Recommendation Report for Listed Building Consent for Alterations, Extension or Demolition

REF NO: AB/132/13/L

LOCATION: 14 Maltravers Street
Arundel

PROPOSAL: Application for Listed Building Consent to create a new En-suite shower room on second floor and insertion of 1no. skylight window

Job Title		
Wall House, Maltravers Street		
Client		
Mr T Tunmore		
Drawing Name		
Proposed Second Floor Plan		
Drawing Status		
Planning		
Drawn by	DF	Date Nov 13
Checked by		Date
Drawing Scale		
1:50 at A3		
Drawing No	Status	Revision
13563/	02

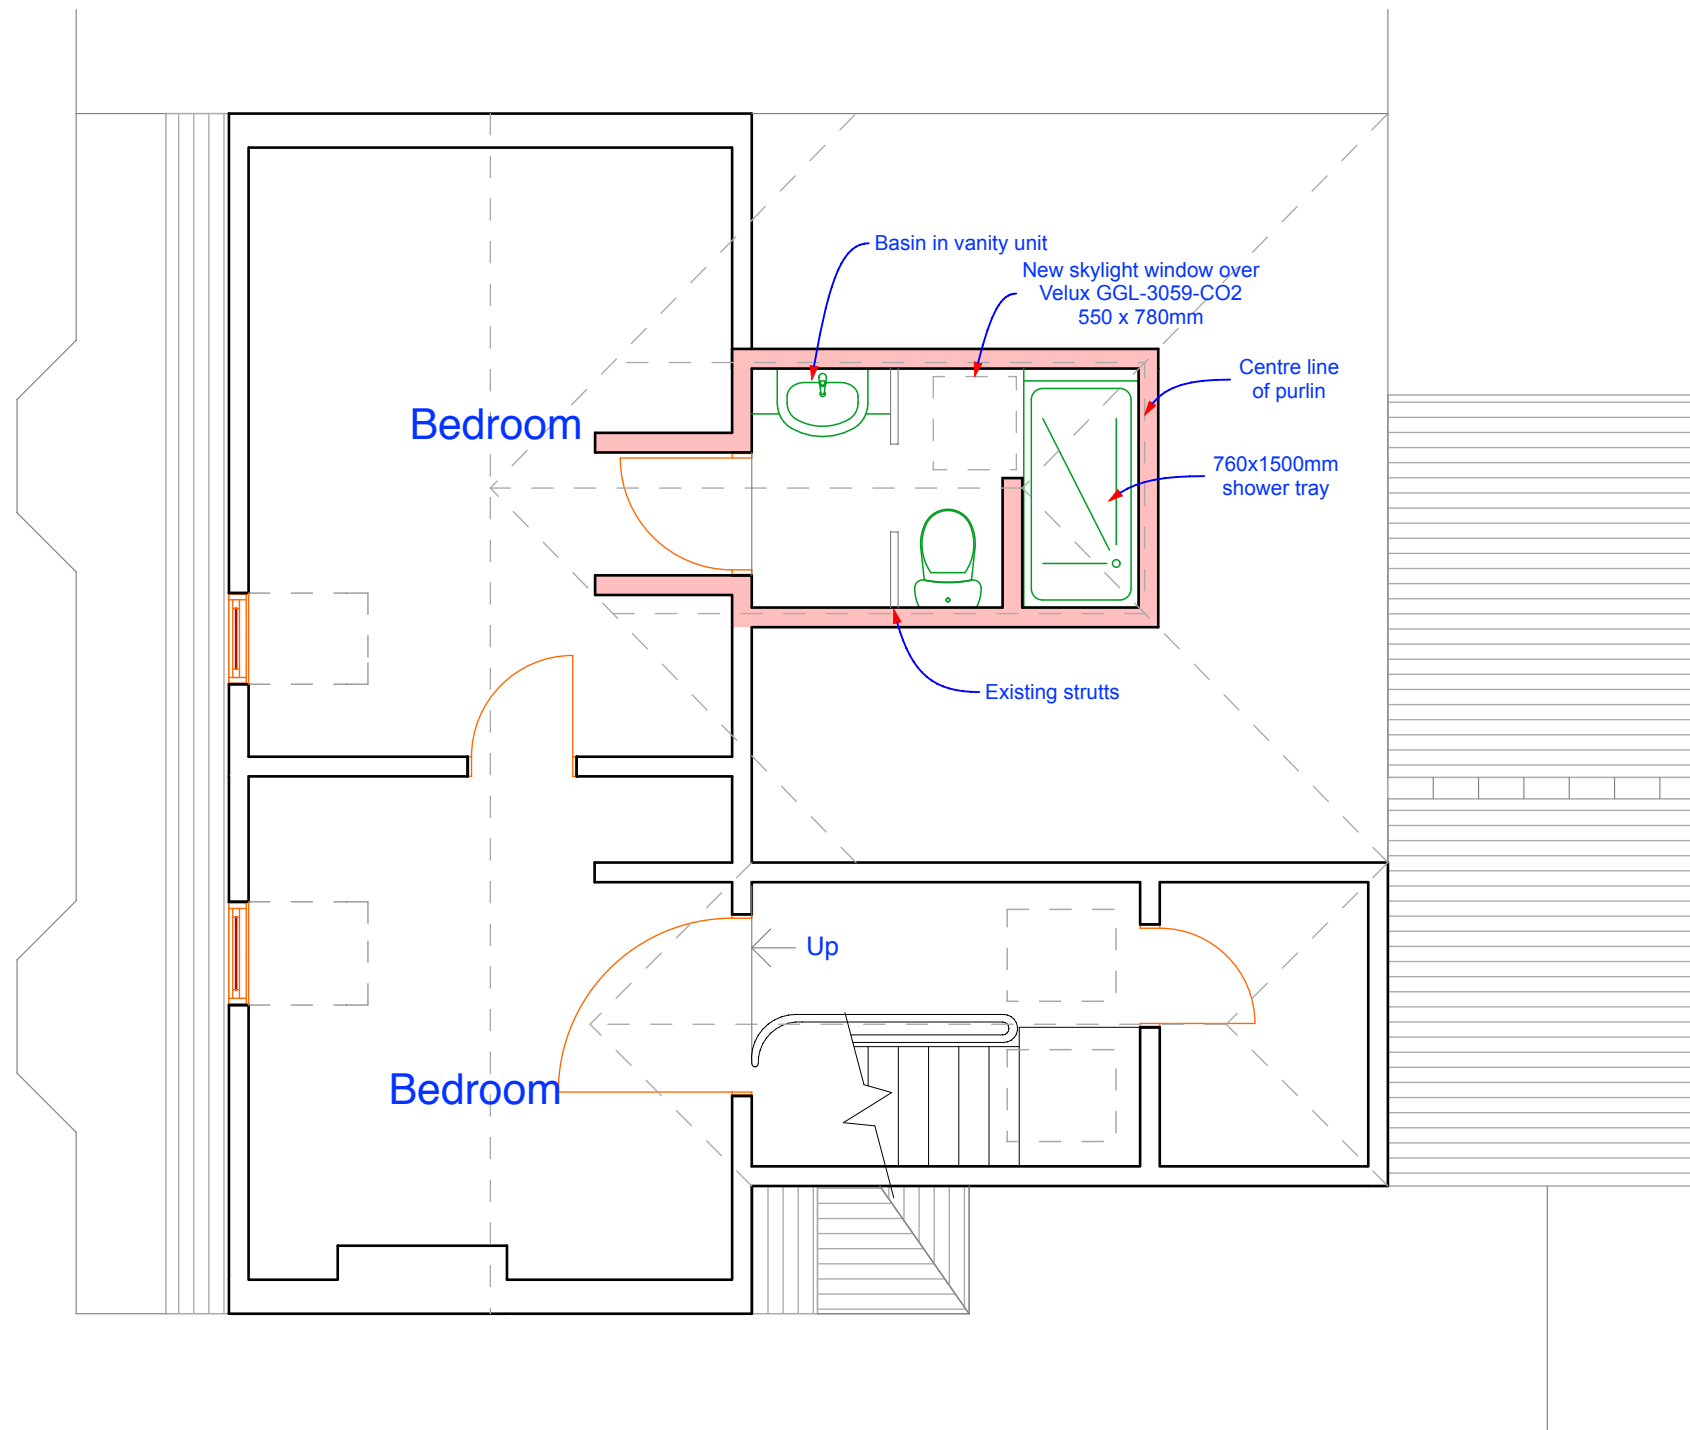
Provided that the skylight is of Conservation grade.

Please condition details of roof light which must be a Conservation type.

No objection. Conservation quality windows to be used.

This application applies for Listed Building Consent to create a new en-suite at second floor level in the property. The existing internal struts of the building are marked for retention and so there will be no detrimental loss to the historic form or noteworthy features set out in the listing certificate as a result of these works.

The proposed skylight window will be situated in the rear west-facing roofslope and in this location will not be readily seen from the road of Maltravers Street or any other public vantage point. The dimensions are small at approximately 0.5m x 0.8m and will not be the sole rooflight in this part of the building. However, a condition is recommended to be placed on the consent requesting that the proposed rooflight is of Conservation standard in response to comments made by the Town Council, Historic Buildings Advisor and the Conservation Area Advisory Committee.

- 3 The rooflight hereby approved shall be of Conservation standard and type. Details to be submitted and agreed by the Local Planning Authority prior to the commencement of any works.
